Appeal Decision

Appeal Ref: 6003016

117 Pinner Road, Pinner Hill HA6 1DA

- The appeal is made under section 78 of the Town and Country Planning Act 1990 (as amended) against a refusal to grant approval required under Article 3(1) and Schedule 2, Part 20, Class AA of the Town and Country Planning (General Permitted Development) (England) Order 2015 (as amended).
 - The appeal is made by Dr V Mittal c/o Lithium Properties against the decision of the Council of the London Borough of Hillingdon.
 - The application Ref is 12055/APP/2025/2416.
 - The development proposed is prior notification to add a single additional floor to create 4 no. flats above existing residential uppers and ground floor retail.
-

Proposed Elevation Pinner Area - 5

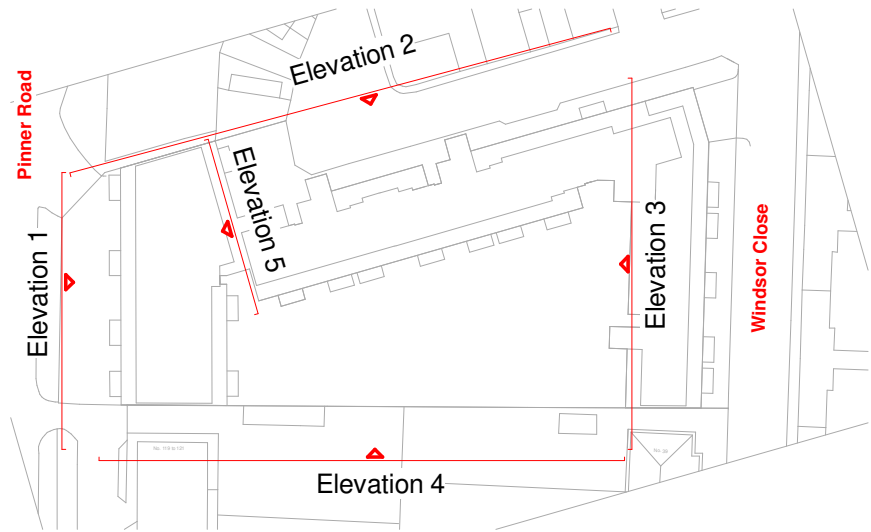
10. The principal elevation of 117 Pinner Road (No 117) has commercial units on the ground floor with residential accommodation above. It is four storeys in height with the fourth floor stepped back from the third. The principal elevation is set slightly back from the established building line of the adjacent three storey property to the east. Its modern design contrasts with the traditional brick built properties making it a prominent feature within the street scene. However, because its roofline forms a gradual stepped transition with the lower three and two storey properties to the west, and its height is only marginally greater than the adjacent prominent three storey building located on the corner of Pinner Road and Joel Street against which it is primarily viewed, the building does not appear harmfully dominant in the locality, nor does it disrupt the relative uniformity and rhythm of the building heights on this part of Pinner Road.

11. The proposed additional storey would use materials that match the fourth floor of the building and would be recessed from the current top floor, thus continuing the stepped appearance of the principal elevation. In this regard, it would not appear top heavy or unbalance the composition of the building itself.

12. However, notwithstanding the above, the increased scale would be highly conspicuous within the street scene. The additional height would make No 117 appear considerably taller than the other buildings in the immediate vicinity, harmfully contrasting with the roof heights of the neighbouring buildings. The proposal would therefore appear as an unduly prominent and incongruous addition and would fail to sit comfortably against the heights of the adjacent buildings. That

the principal elevation of the appeal building is set back from the neighbouring buildings would not mitigate its prominence or harmful visual effect.

15. In conclusion, I find the proposal would not be acceptable in terms of its external appearance, having an adverse effect on the locality by reason of its design through the increased height and scale. Accordingly, it would not comply with paragraph AA.2 (1)(e) of Schedule 2, Part 20, Class AA of the GPDO.
